Your Ref: OWPC19636
Our Ref: AL/74/18/PL
Please ask for:
Mr S Davis

Insertion of 1 No. dormer window to front elevation of Plot 1 & alterations to front door surrounds following the grant of AL/5/18/RES.

Woodgate Farm Westergate Street Westergate

title:	Plot 1 Elevation, 2nd Floor Plan & Roof Plan
--------	--

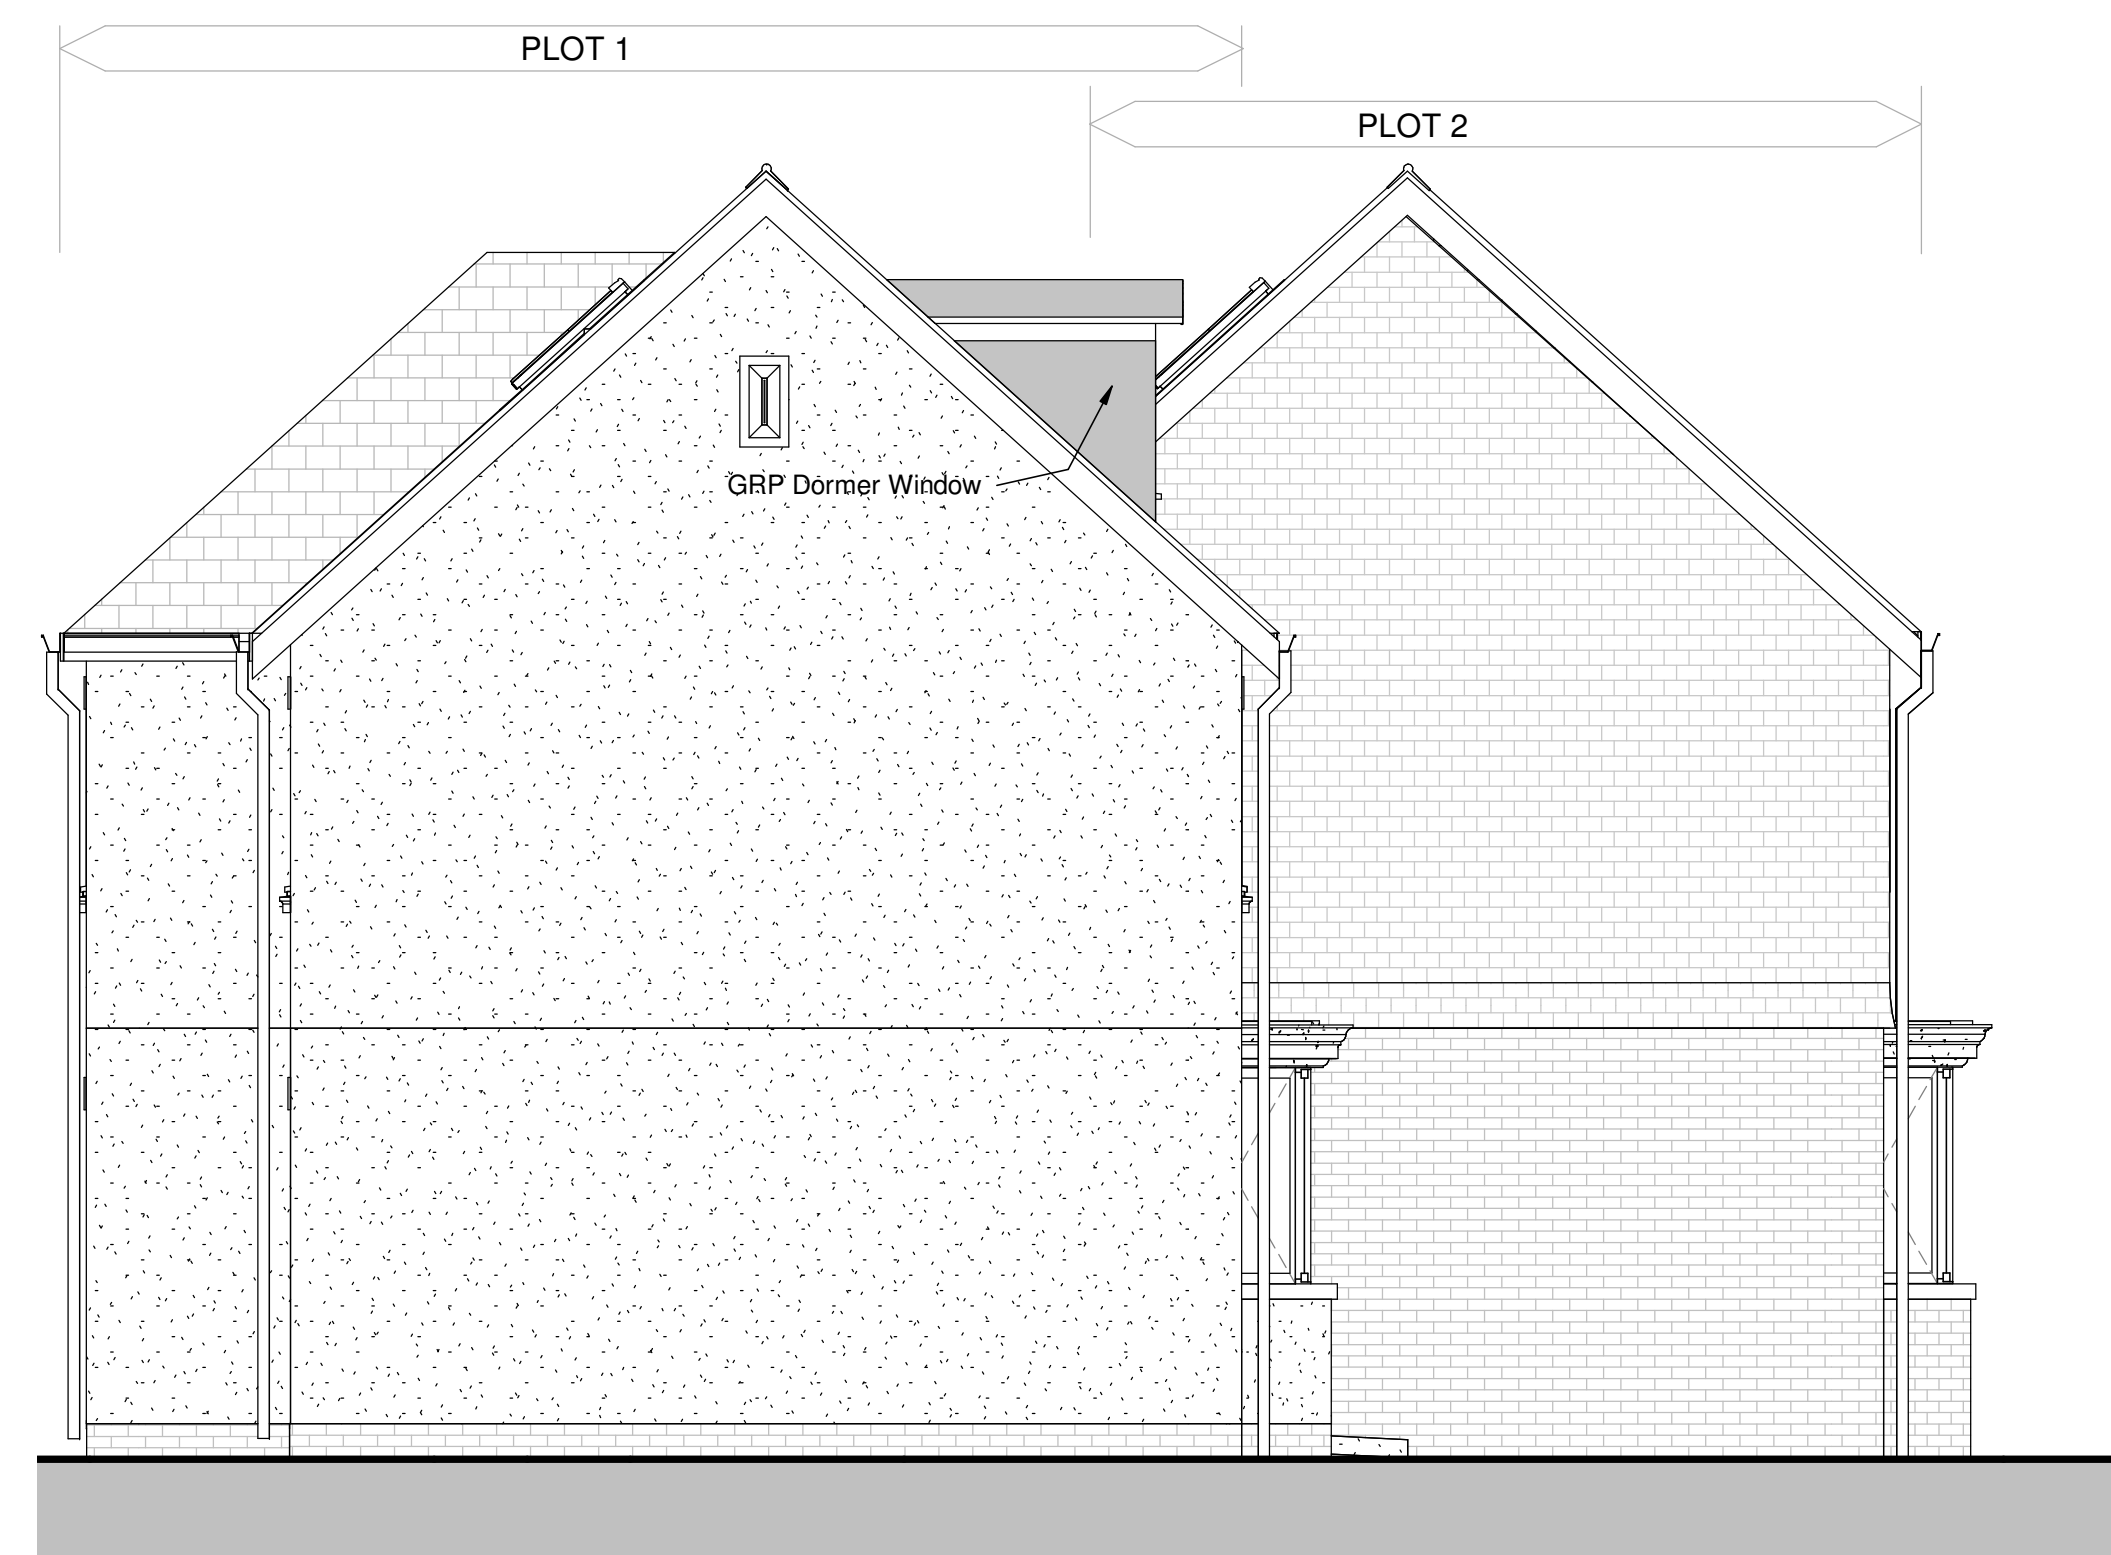
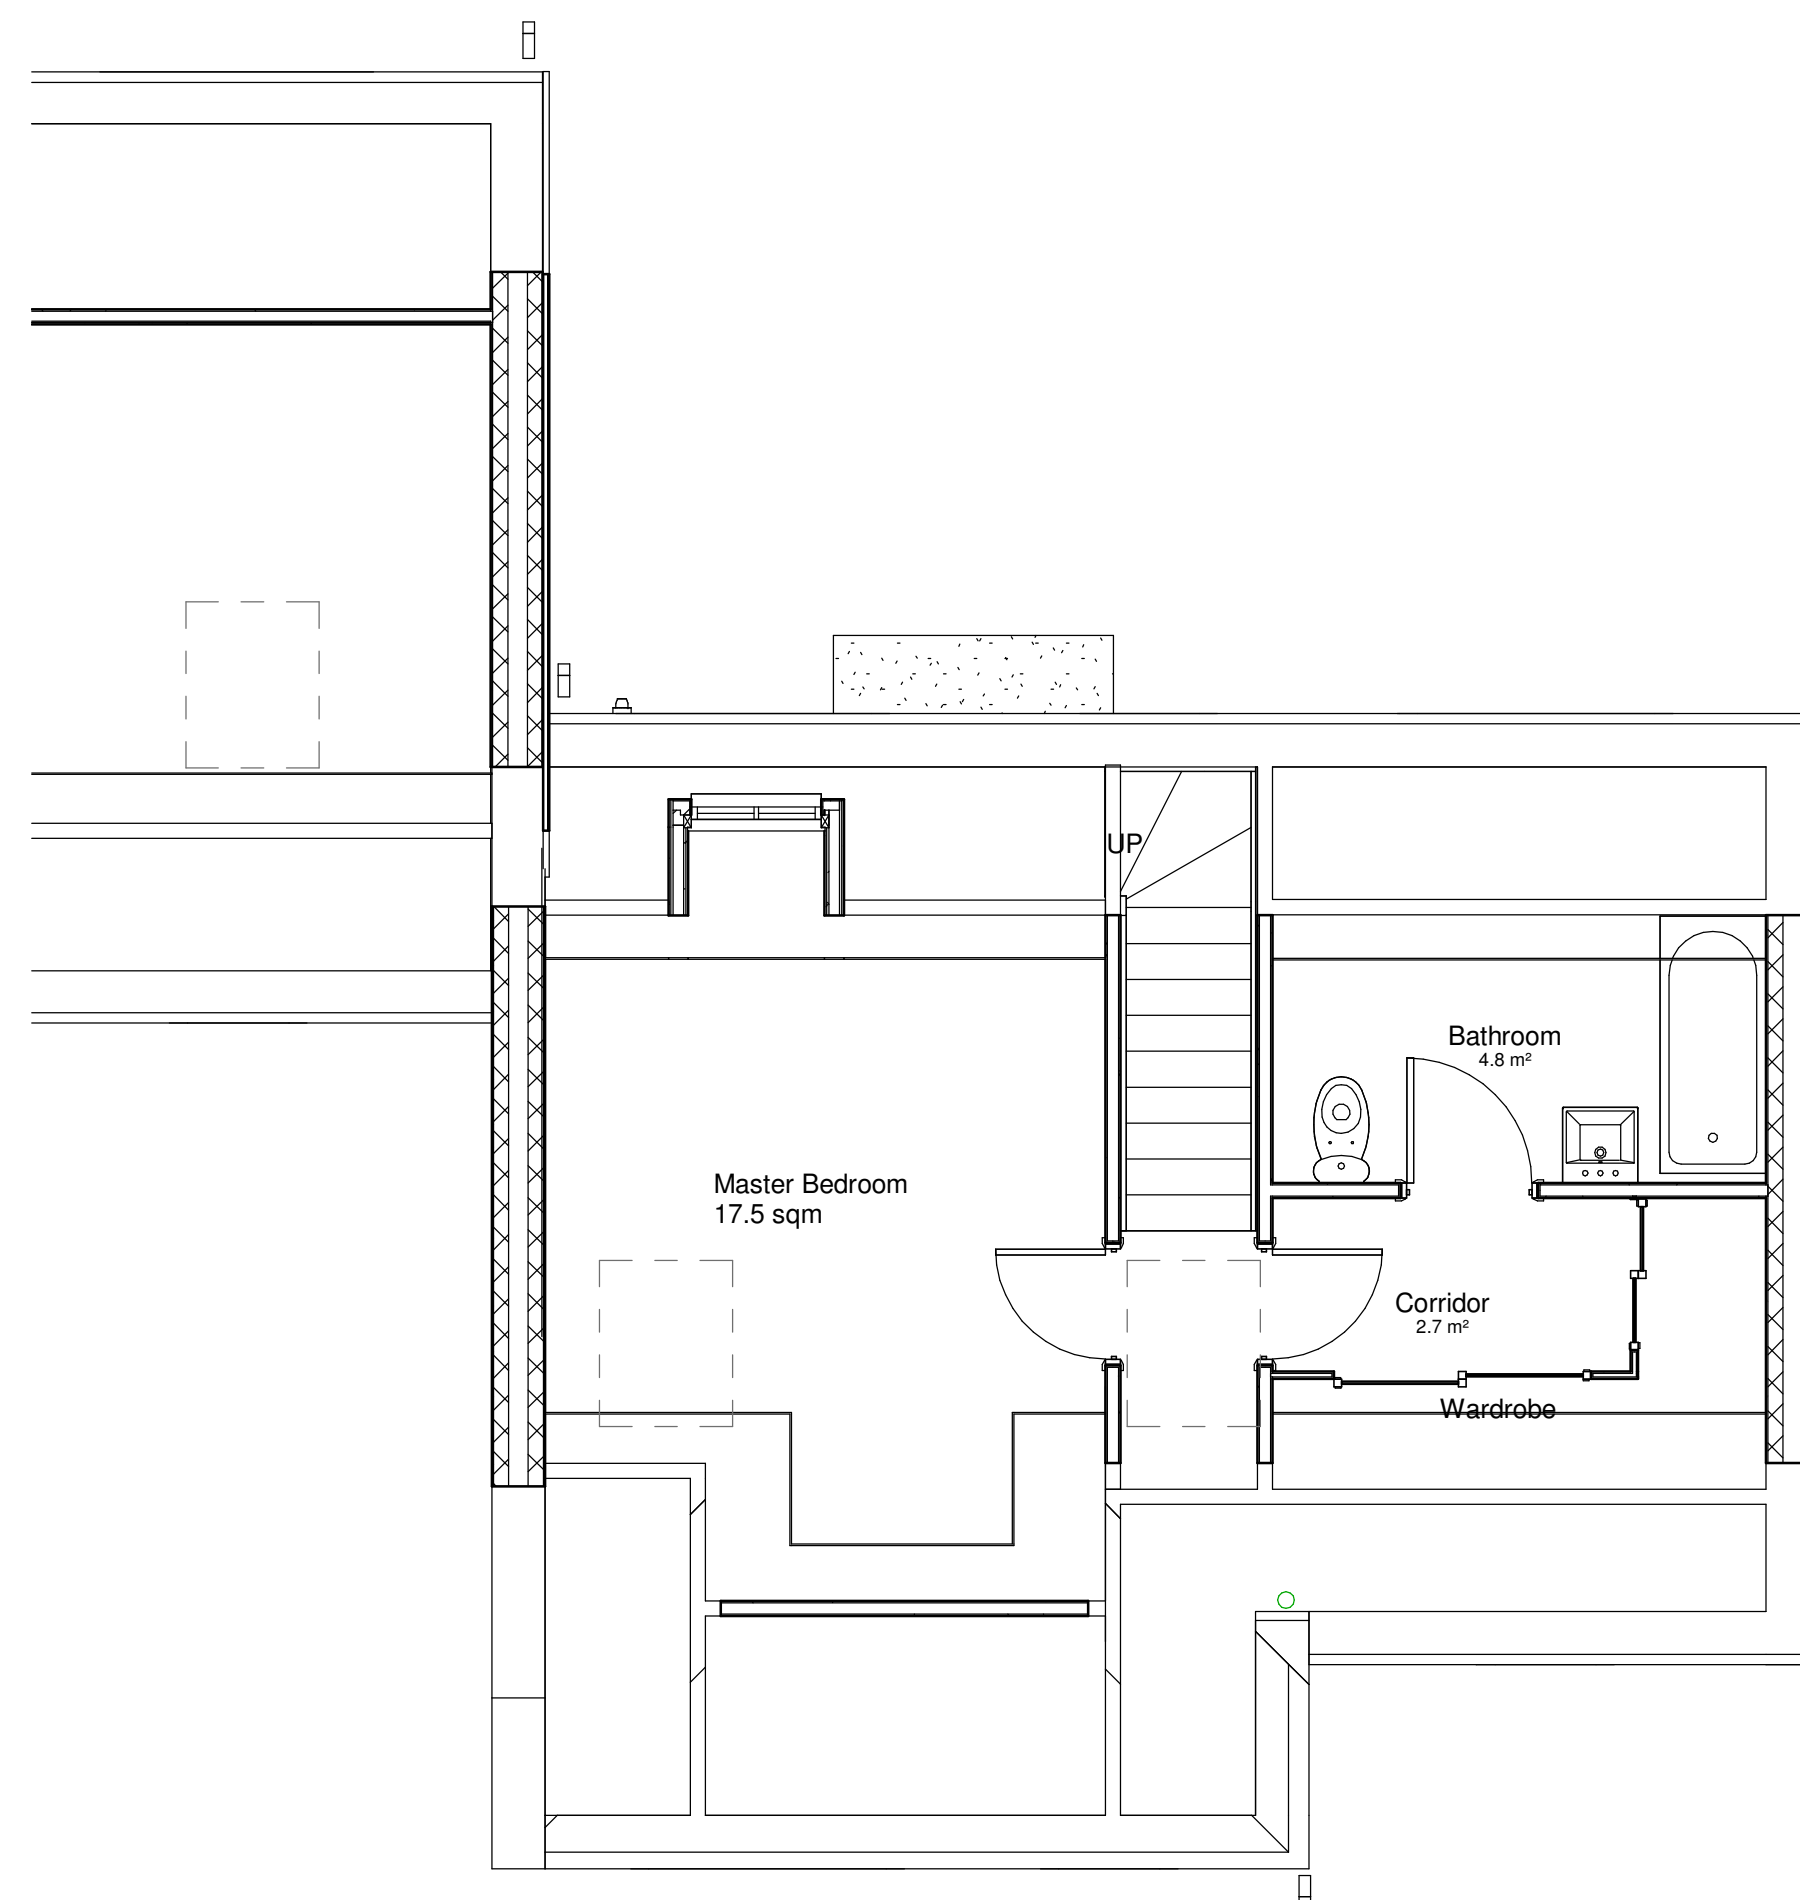
Contrary to policy H1 of the APC NP, the proposed dormer is not in keeping with surrounding properties.
